**Consultation Response from: KC Environmental Health (Pollution & Noise Control)**
**2021/93305 - 61-65 New Street, Huddersfield, HD1 2BQ**
**Change of use and conversion of existing buildings, erection of split-level seven storey extension comprising four-storey stairwell, five-storey roof-top tower block and enclosed courtyard to form 31dwellings and sub-division of the retail unit forming 61-63 New Street (Listed Building within a Conservation Area)**
**Responding Date:  
26 April 2023**
**Responding Officer:  
Mohammed Nasim**
**Responding Ref:  
WK202311369**
**Comments**
**Noise**

Figure 2.0 – Façade Colour Grouping

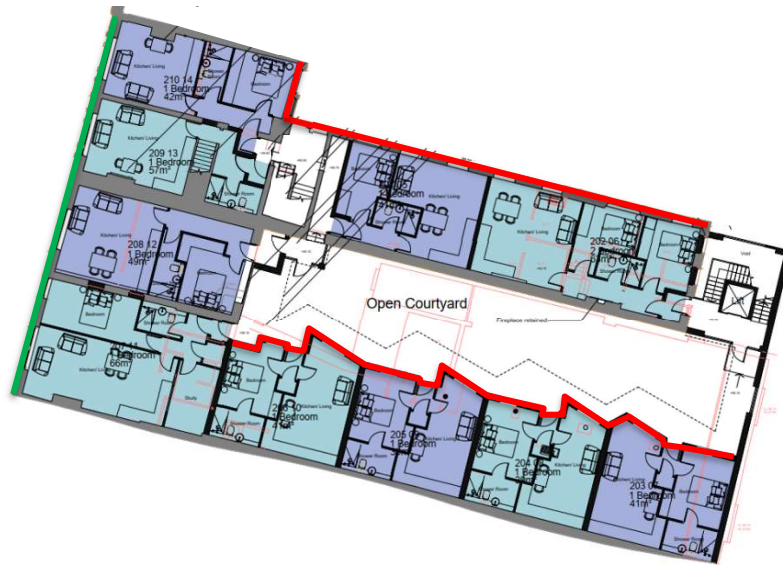
In order to correctly specify the required sound reduction, the façades have been divided into two colour groups: red and green and appropriate models of glazing and ventilation for each façade colour are shown in tables 6 to 8. Secondary glazing and double-glazing options have been given for both façades as it is thought the new extension to the building is likely to have double-glazing installed. This will need to be stated and the respective mitigation measures installed.
